**RE: Bogan Warehouse
Grading and Drainage Plan
Engineer's Stamp Date: 6/24/24
Hydrology File: F17D106**

Based upon the information provided in your submittal received 06/28/2024, the Grading & Drainage Plans **are not** approved for Building Permit Approval. The following comments need to be addressed for approval of the above referenced project:

**Asbuilt TRACT 4 REINDEER ADDITION**

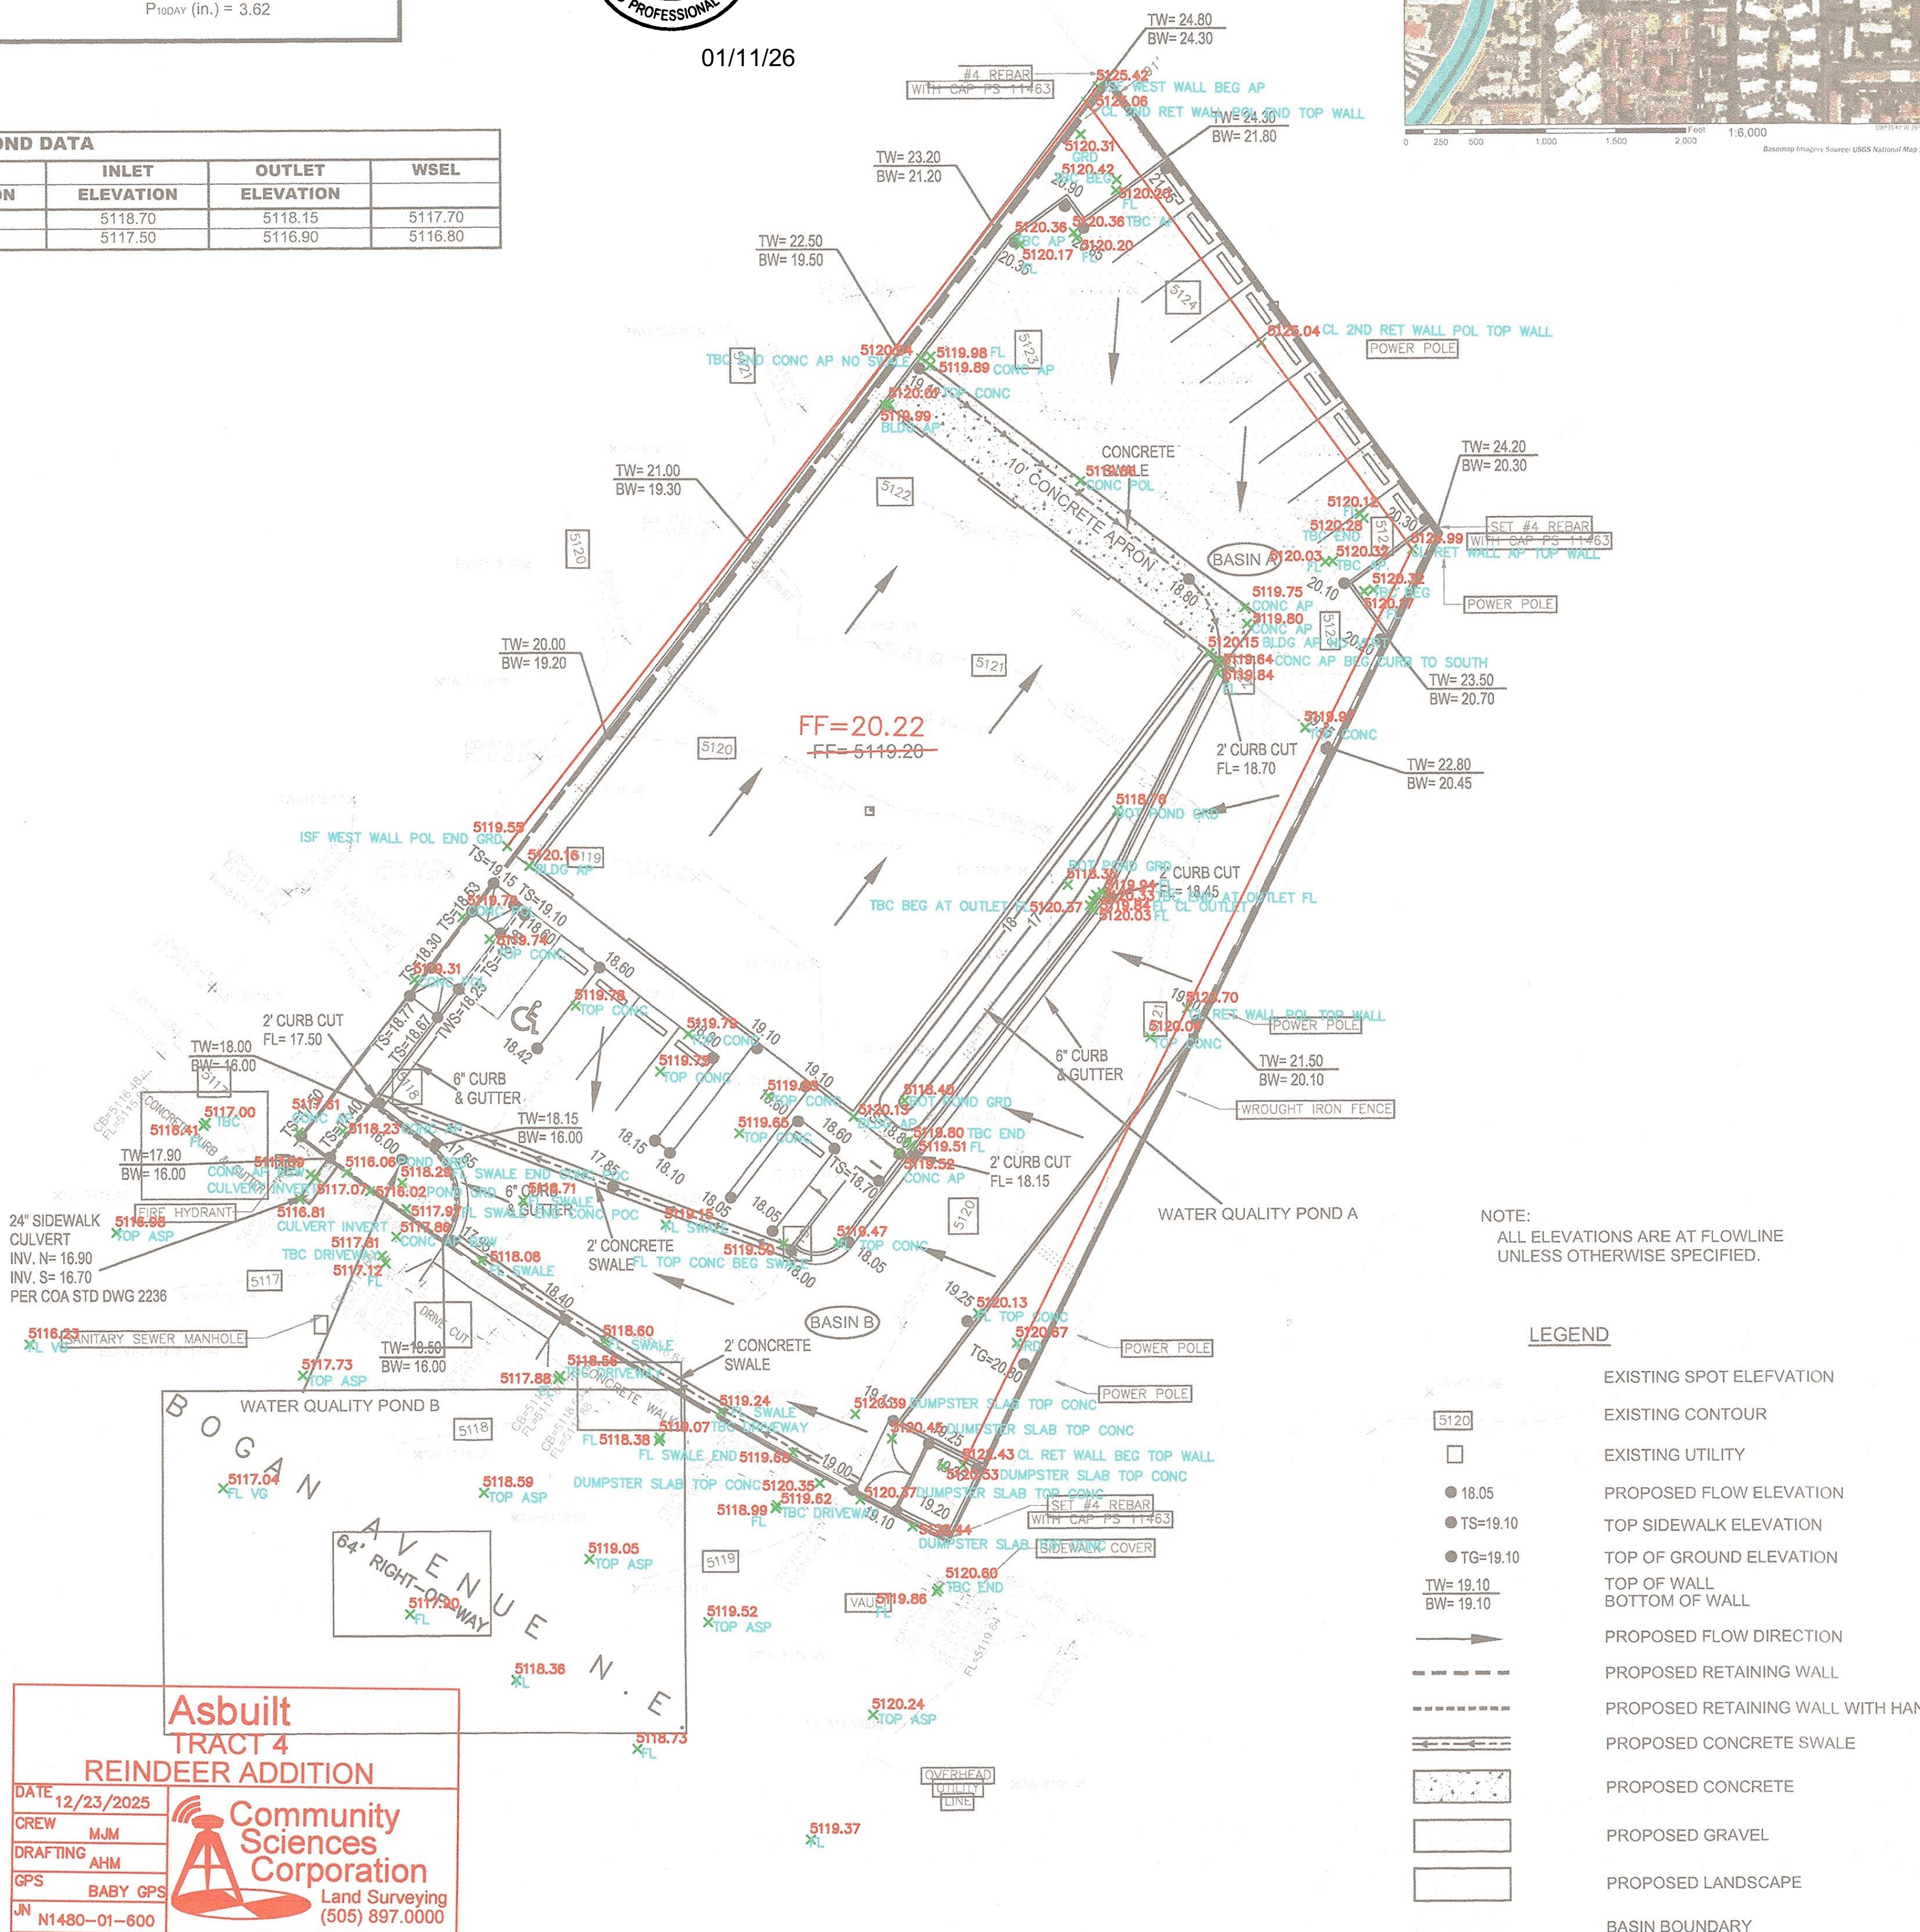
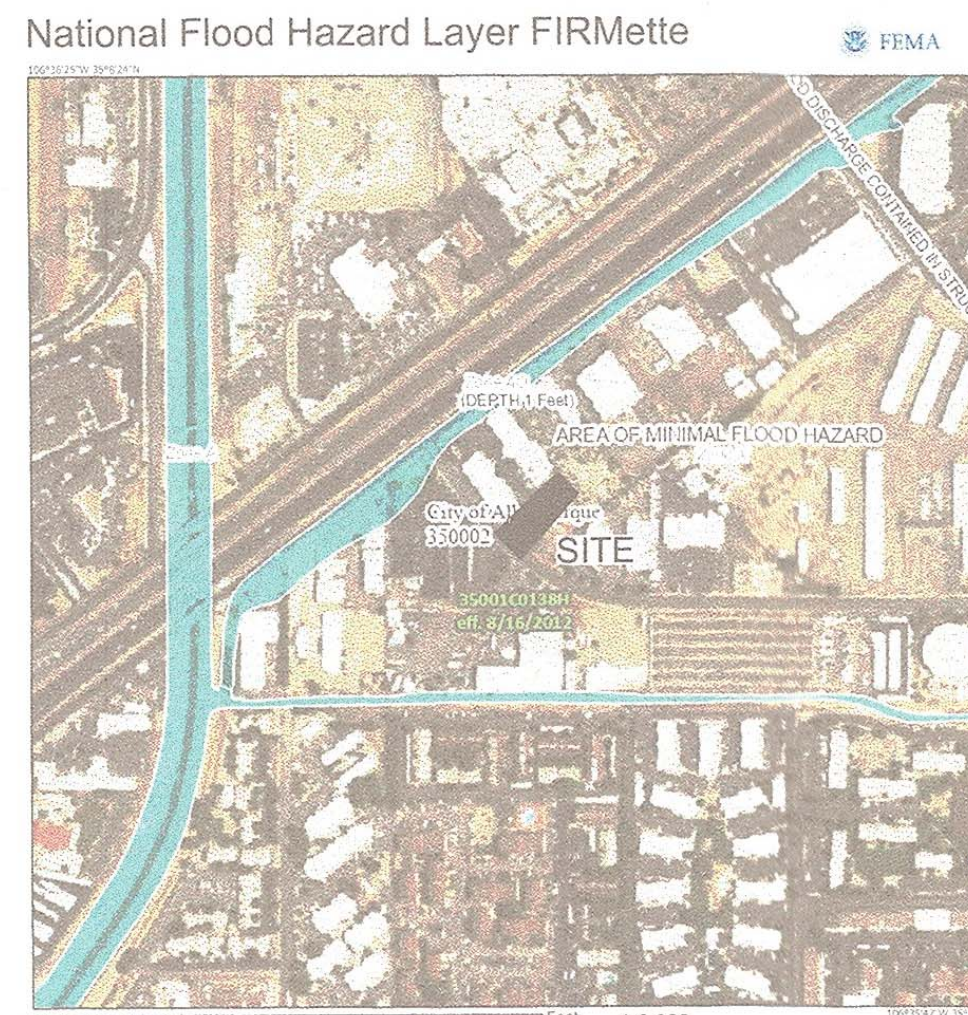
1. An SO-19 Permit will be required and should be included on the request. Please include the [standard SO-19](#) notes on the grading plan.
2. Please provide the Benchmark information (location, description and elevation) for the survey contour information provided
3. Please provide the FIRM Map referenced in the Plan.
4. Please number the ponds and include a label on each with the SWQV and elevation, the 100-year volume and elevation, the peak 100 year inflow and outflow, the spillway crest elevation, the spillway flow depth, and the dam top elevation.
5. Please provide the SWQV calculations for each basin draining to each pond. The stormwater quality ponds need to be sized for the areas draining to them.
